Planning Application Ref: AW/321/13/T

Location : Qualitas, 11 Barrack Lane, Aldwick

Description of work:

PLAN REF NO 'SELWAY PLAN I'
30.11.13.

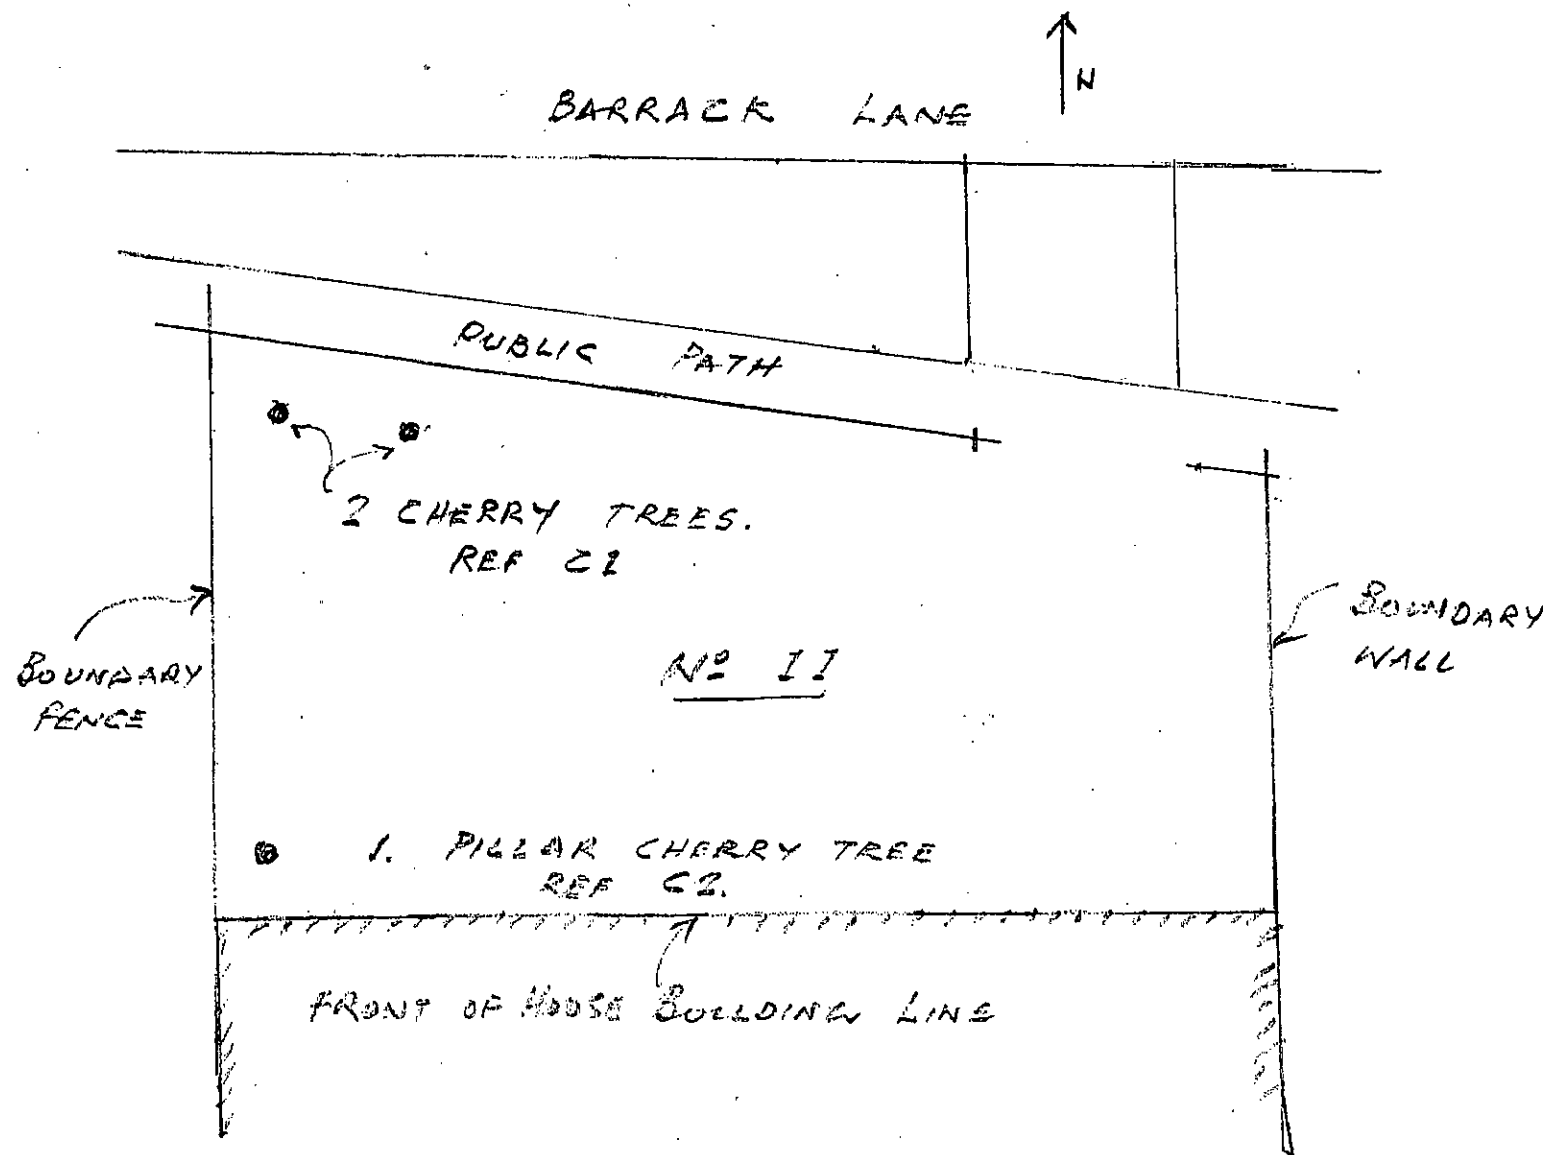
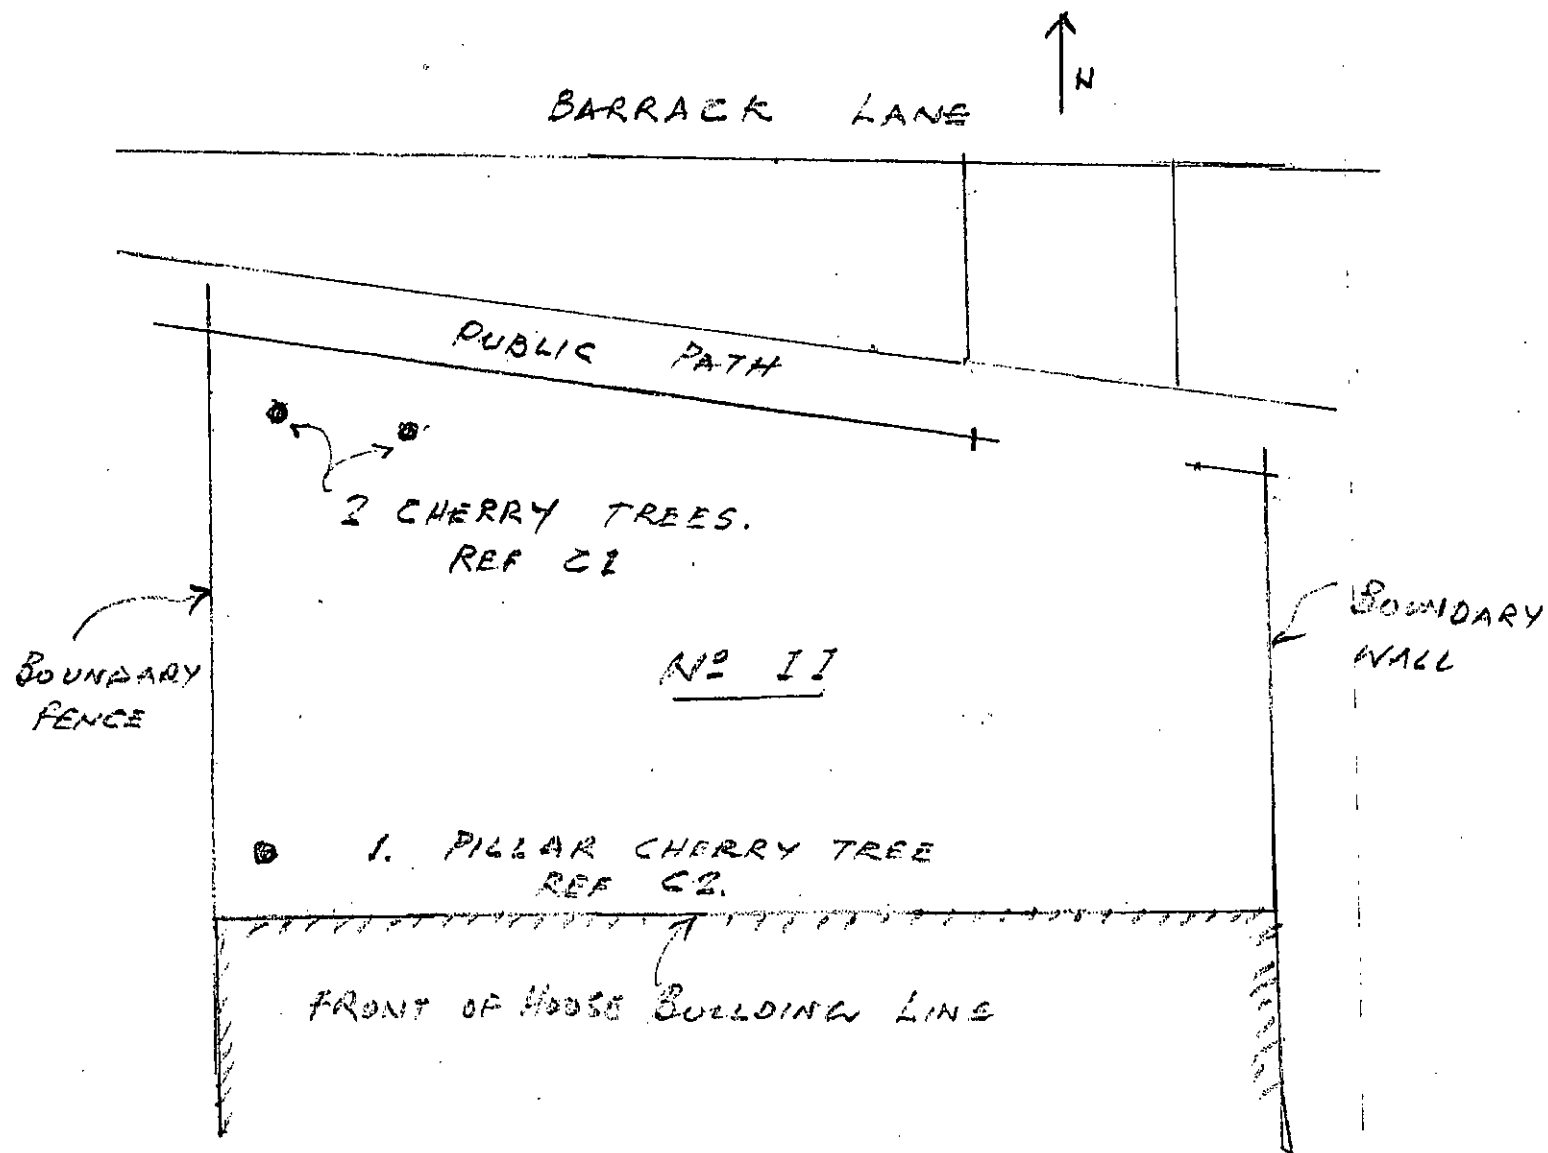
General Observation – these trees have all been heavily lopped and topped before so this operation is repeat pruning work.

T1 – Wild Cherry - x 2 of - Avge Height – 6m : Avge Spread – 3.5m : Age – Semi Mature

- Has previously been reduced down in height by 2m and spread by 1m to 1.5m

T2 – Fastigate Japanese Cherry Avge Height – 4m : Avge Spread – 0.7m : Age – Semi Mature

- Has previously been reduced down in height by 0.5m to 1m but nothing off the laterals because of its fastigate habit

I agree to pruning down **no further than the previous pruning points** on all three trees :-

= 2 Wild Cherries – reduce in height by a maximum of 2m and reduce lateral spread overall by 1m

= 1 Fastigate Cherry – reduce in height by a maximum of 1m but **NO** reduction of laterals permitted.

N.B.- No stubs devoid of foliage or living growth points to be left and in the case of the Fastigate Cherry round off the top so that it is not left flat in appearance
